**WEST SUSSEX COUNTY COUNCIL
STRATEGIC PLANNING CONSULTATION**

**SUBJECT: BN/29/15/PL - Solar park , Land at Barnham Court, Church Lane, Barnham,
West Sussex.**

**Updated response to CMP submitted by applicant in email on 6th October
2015.**

Figure 4 - Public Rights of Way (PRoW) Network

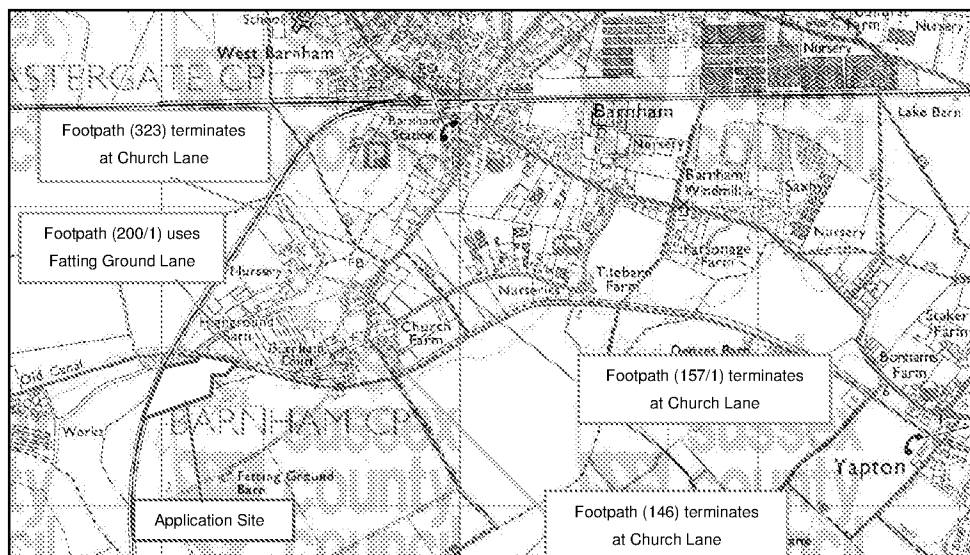
Having looked through there is reference to warning signs being placed at each point along Church Lane where Public footpaths join it, to inform users of the possibility of approaching goods vehicle traffic but there is very little reference to signage at other points along the rights of way network, particularly FP200/1, where there is likely to be some level of conflict. It would be good that if at some stage the route of vehicular access could be clarified so we know whether it is running on the footpath or adjacent to it and if adjacent I would advise some sort of temporary fencing to keep users off the vehicular route.

As well as this I think warning signs at the point where the vehicular access crosses FP200/1 would be necessary as well as the surface improvements to this short section to safeguard it for lawful use as well as vehicles, as set out in my previous comments.

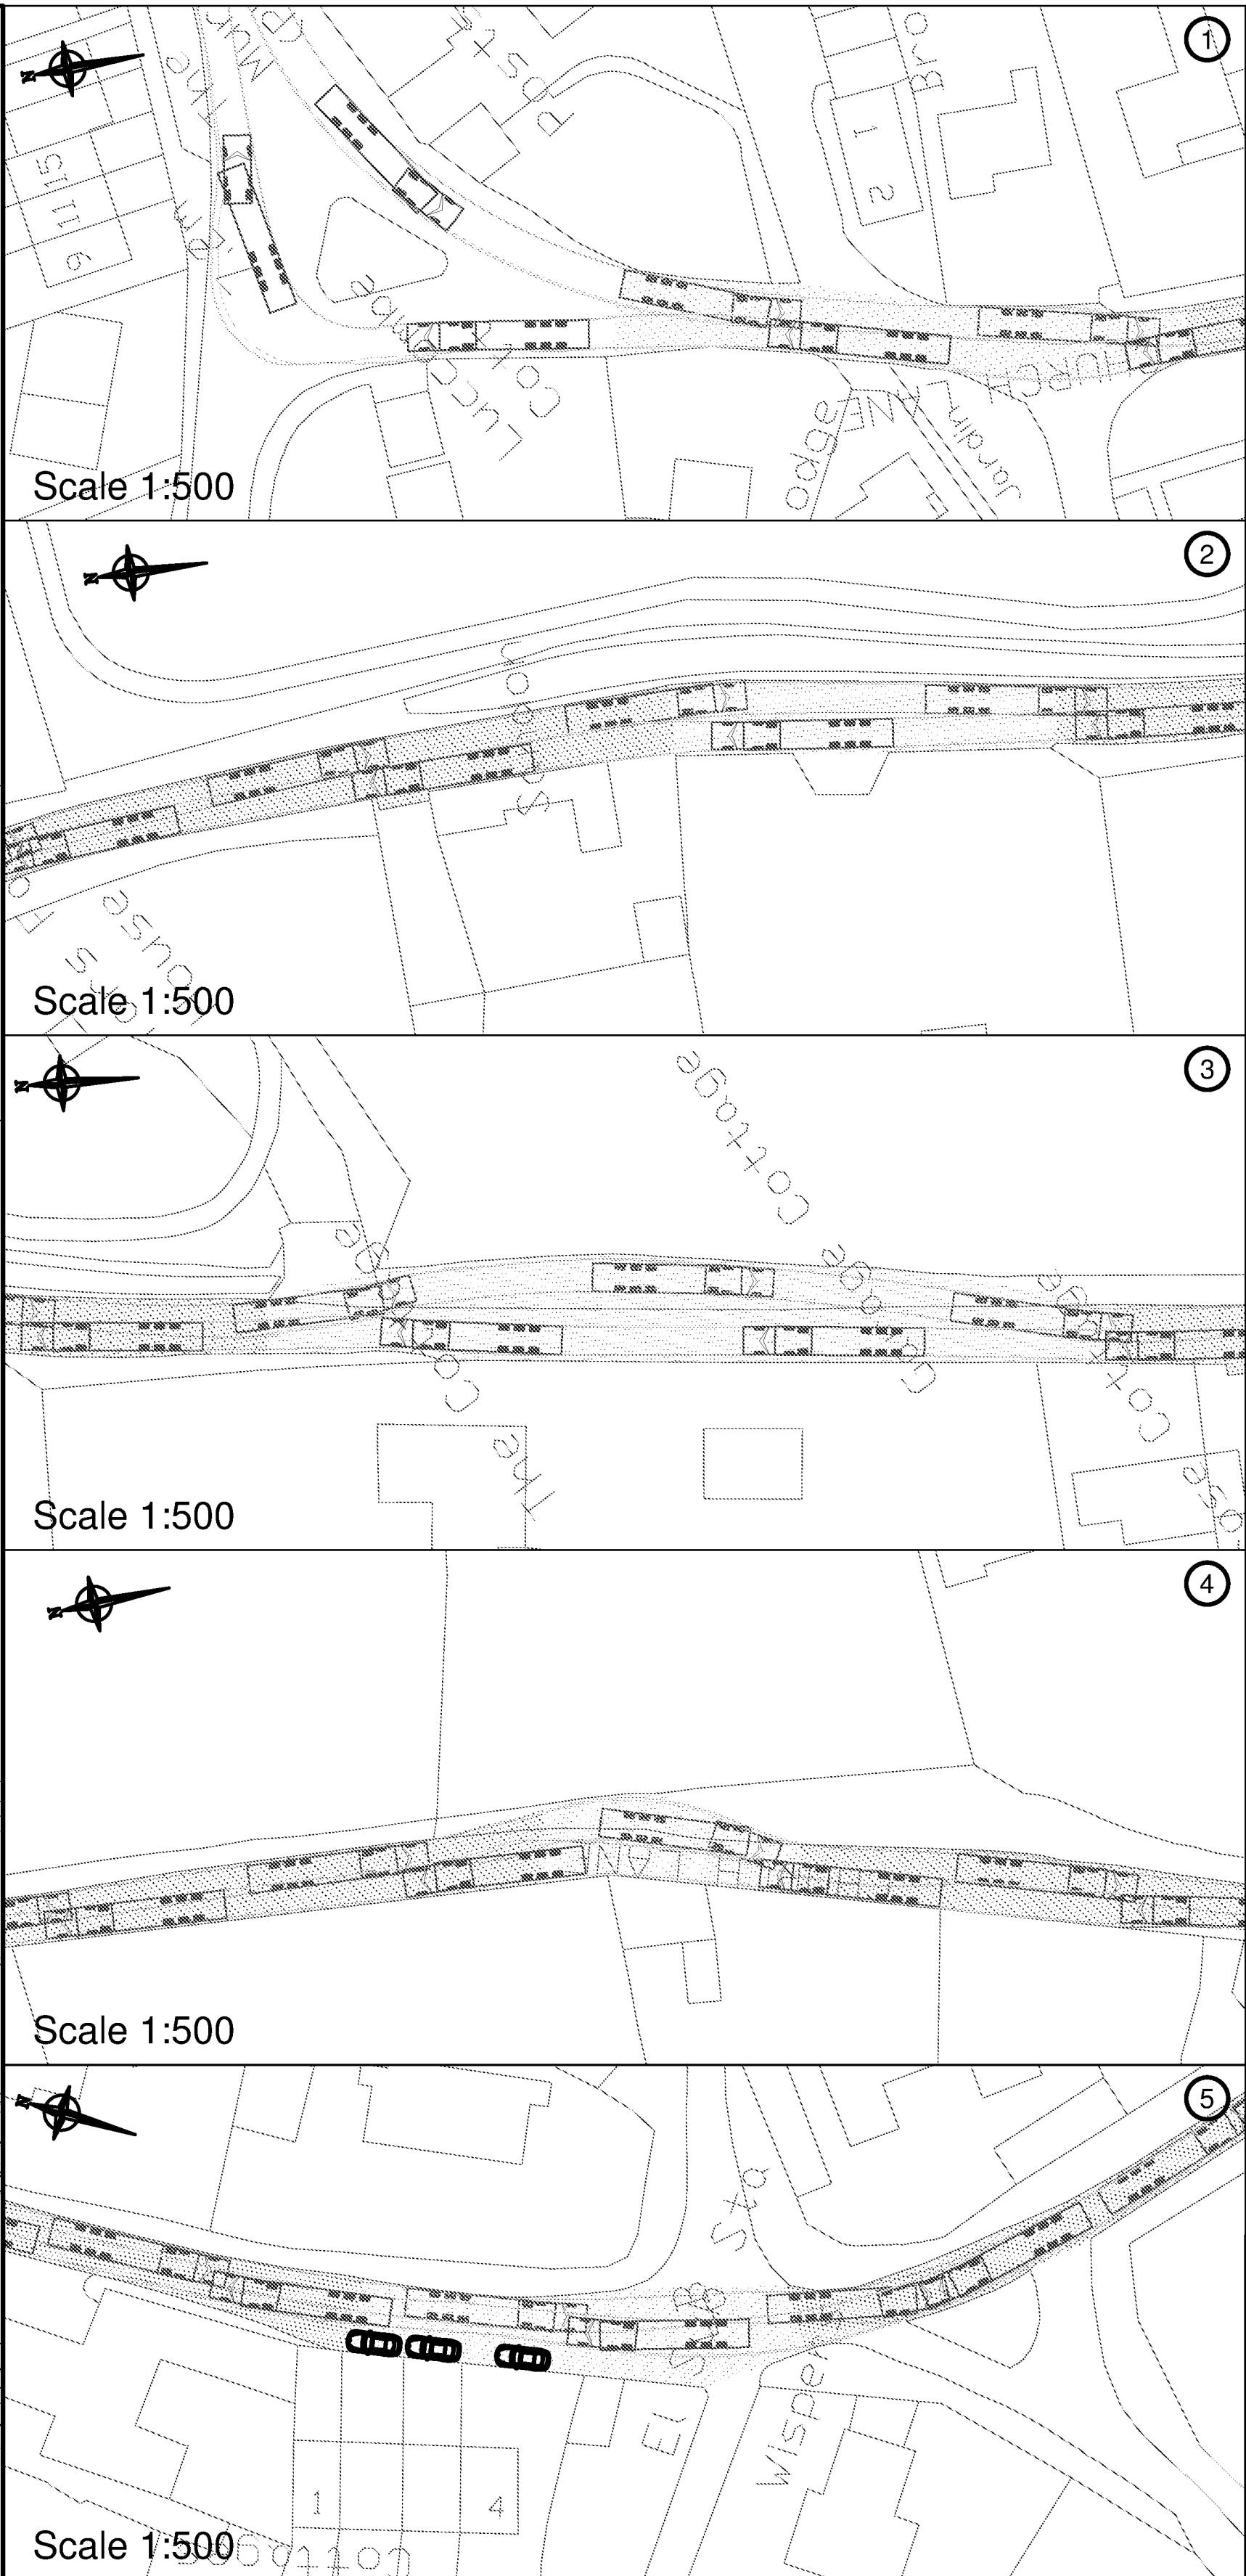
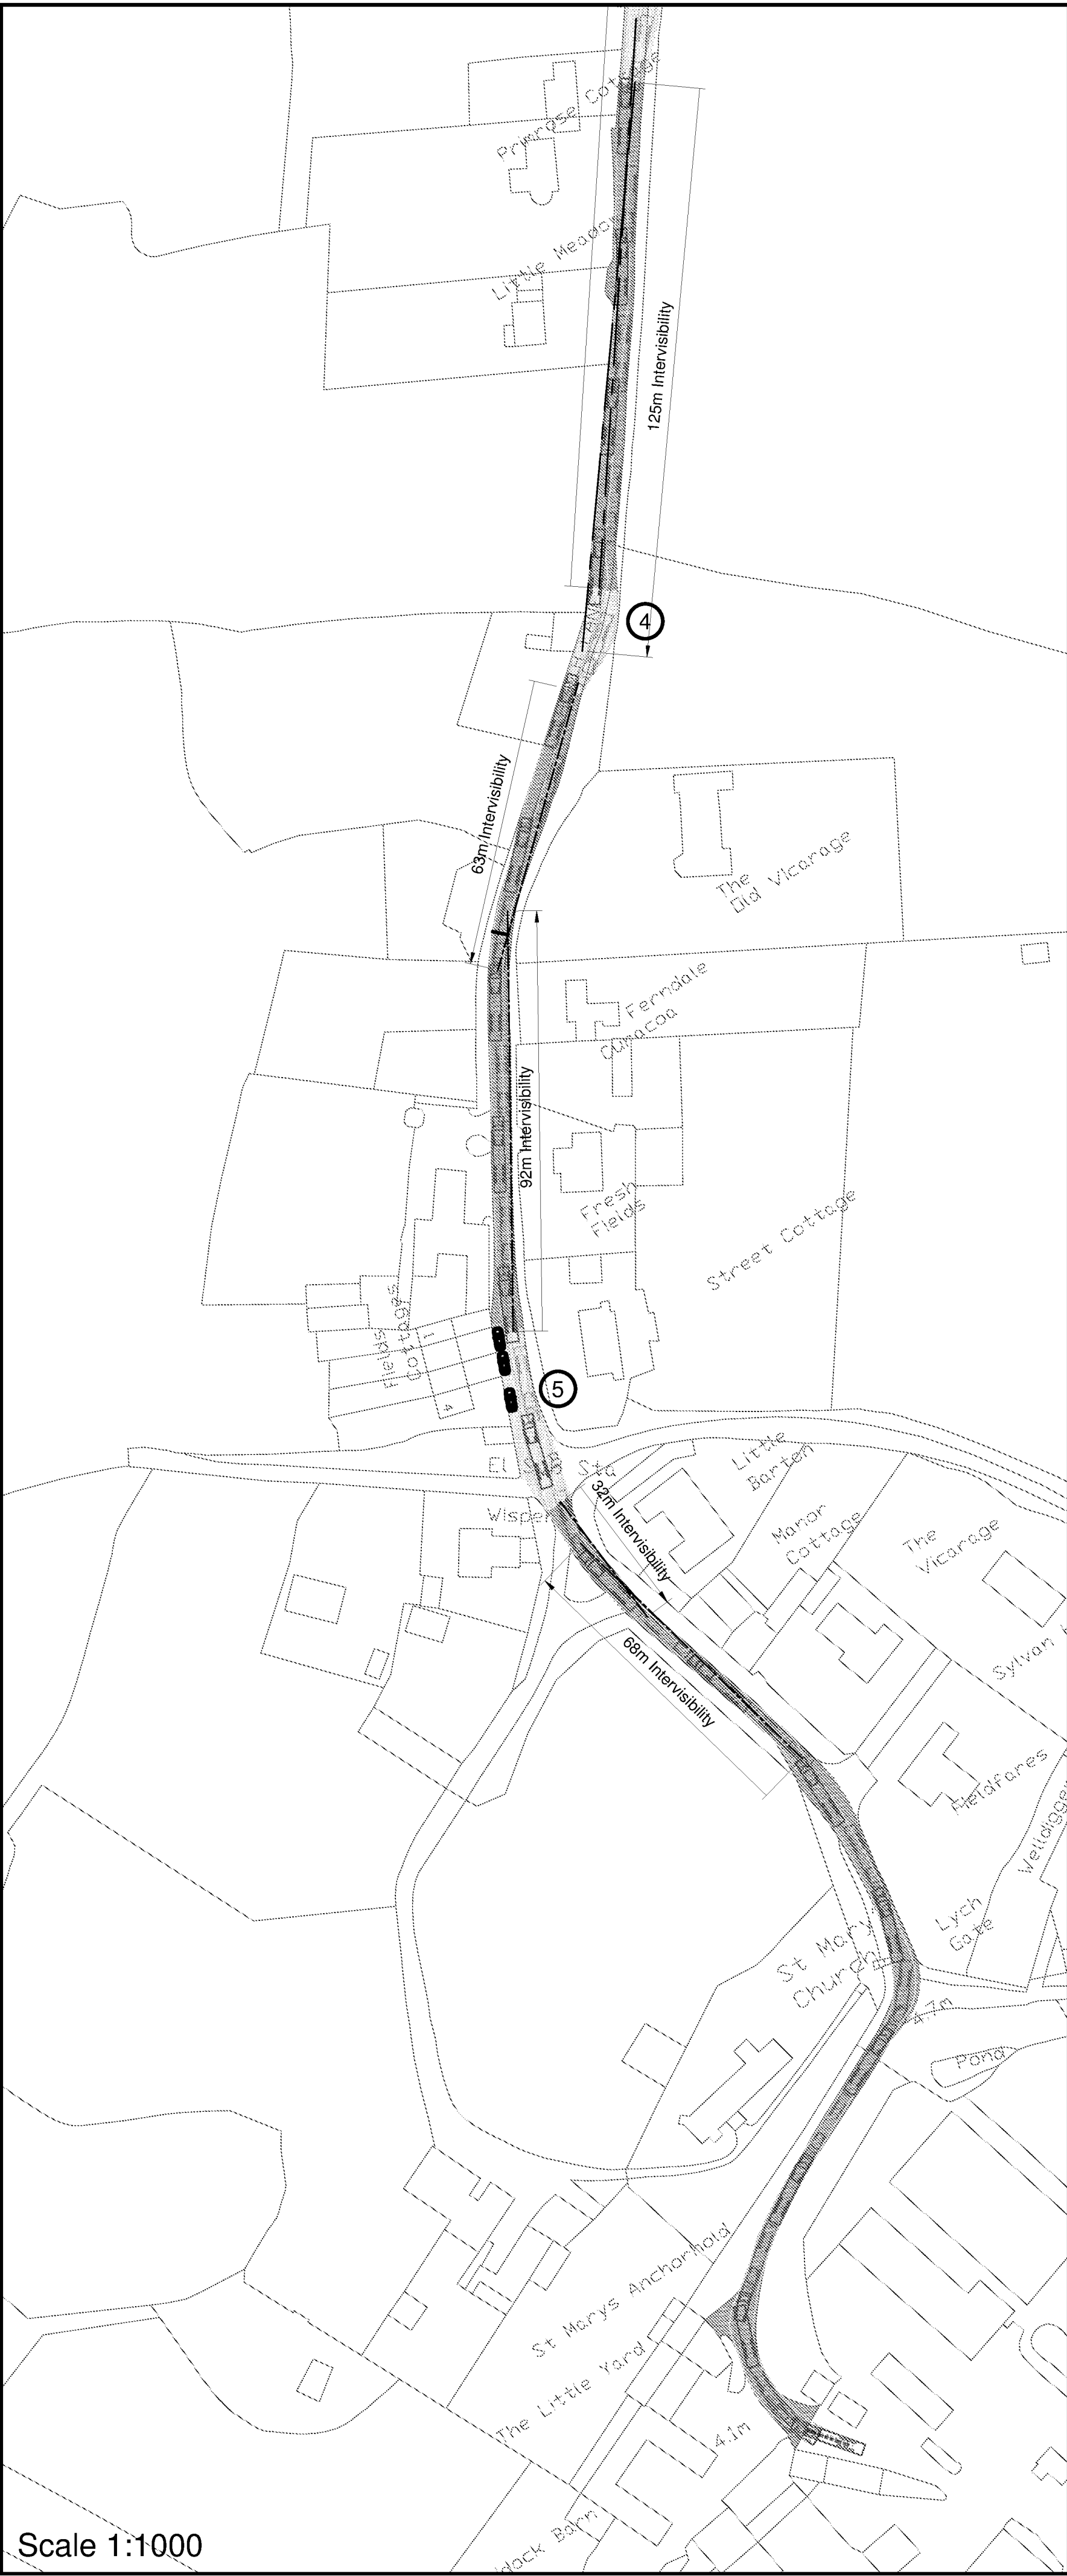
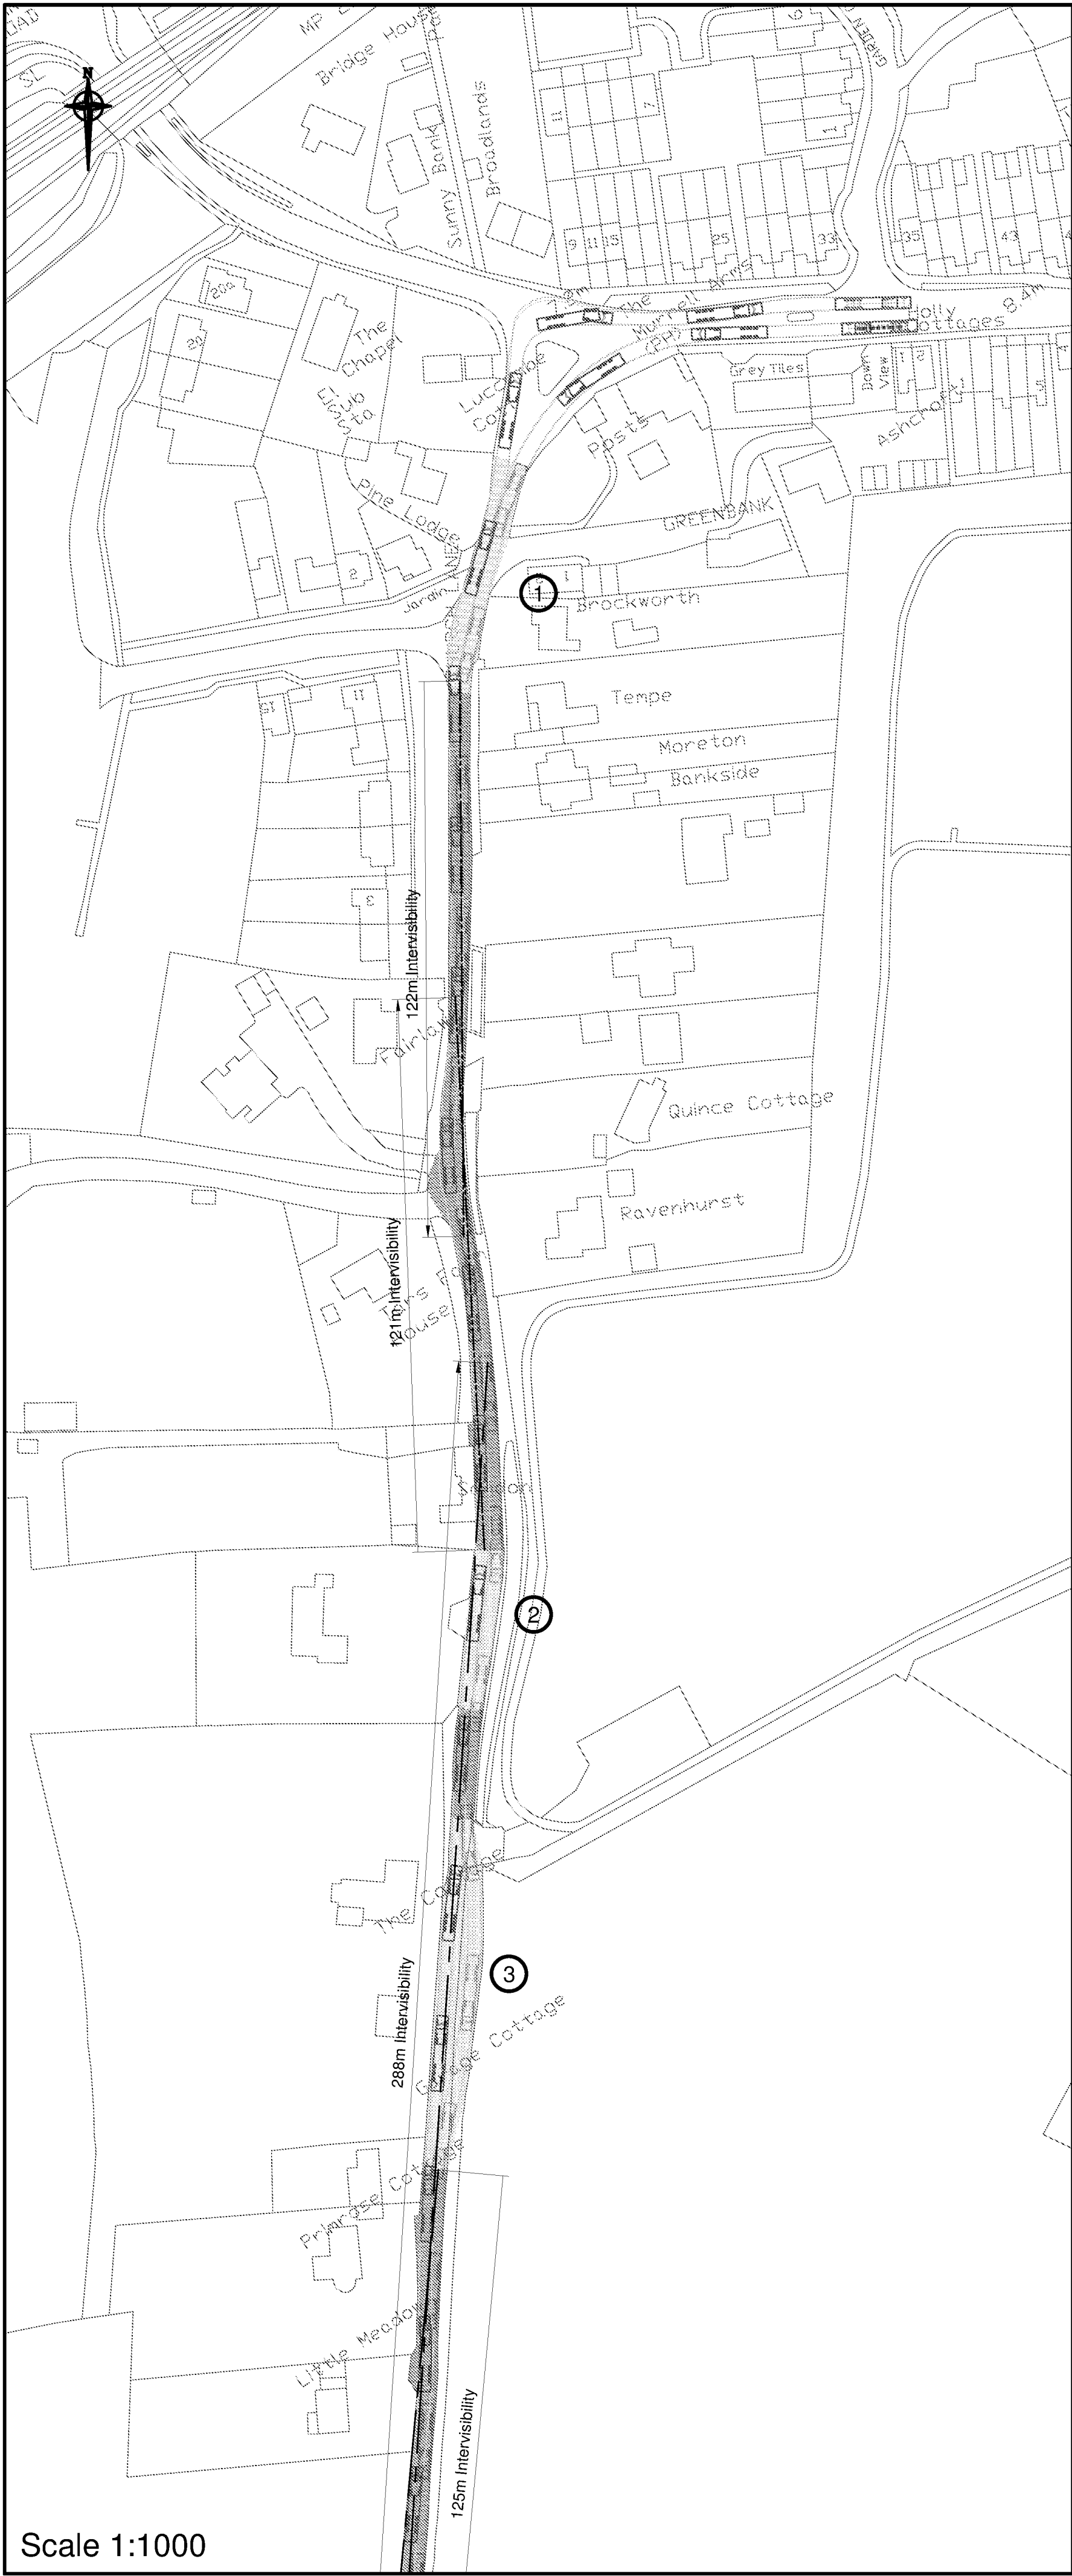
Swept paths provide evidence these can use the junction even with parked cars.

Swept Path diagrams provided for the entire length of Church Lane, indicate where there is good forward visibility, passing places, and also areas which will need management. A package of measures has been proposed to deal with these places which are narrow and cannot accommodate two passing vehicles. These are:-

As mentioned earlier as part of the routing agreement the parking of vehicles at the junction of Church Lane and Yapton Road, might need to be temporarily restricted to ensure the HGV vehicles can make the turn into the lane.
